# Adams School Redevelopment

## **Addendum No. 1** to Contract Documents

March 16, 2012

B5 PLAN DETAIL @ 1HR PARTITION
1 1/2" = 1'-0"

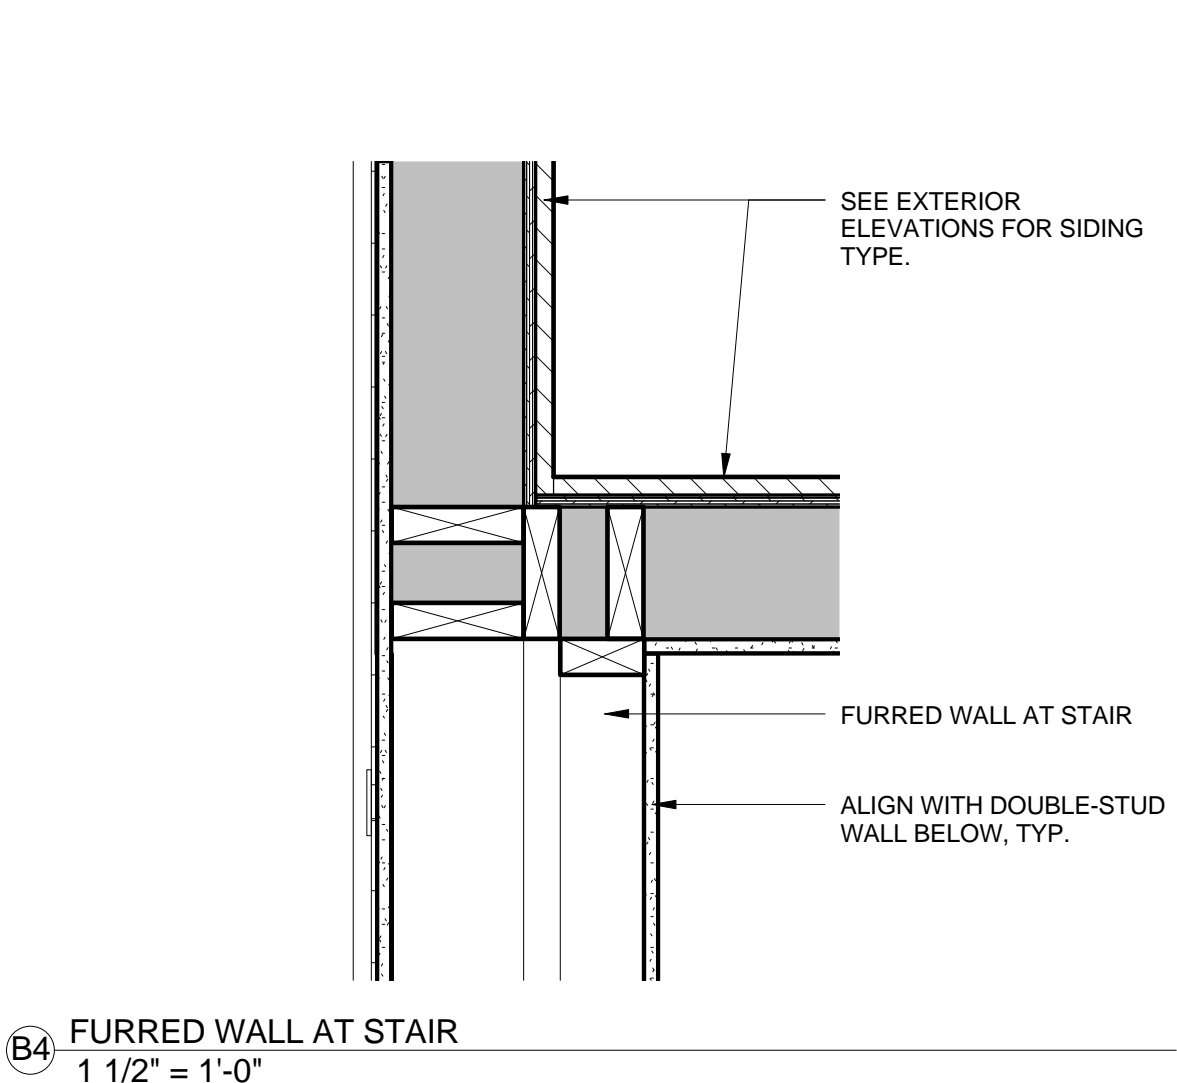
- A. Detail B5/A500: CHANGE note “Dense-Packed Cellulose, Typ.” to: “Spray-Applied Cellulose Insulation.”
- B. Details A2, C2, A4, C4/A501: CHANGE notes “R-21 Dense Pack Cavity Insulation” to “Spray-Applied Cellulose Insulation.”
- C. Detail A2/A501: ADD note at the insulation over the bay window: “Foamed-in-Place Insulation.”
- D. Details A2, D1, D3, C5/A502: CHANGE notes “R-21 Dense Pack Cavity Insulation” to “Spray-Applied Cellulose Insulation.”
- E. Detail B5/A502: CHANGE note “R-21 Dense Pack Cavity Insulation” to “Foamed-in-Place Insulation.”
- F. Detail D1/A503: CHANGE note “Dense-Pack Cellulose insul” to “Spray-Applied Cellulose Insulation.”
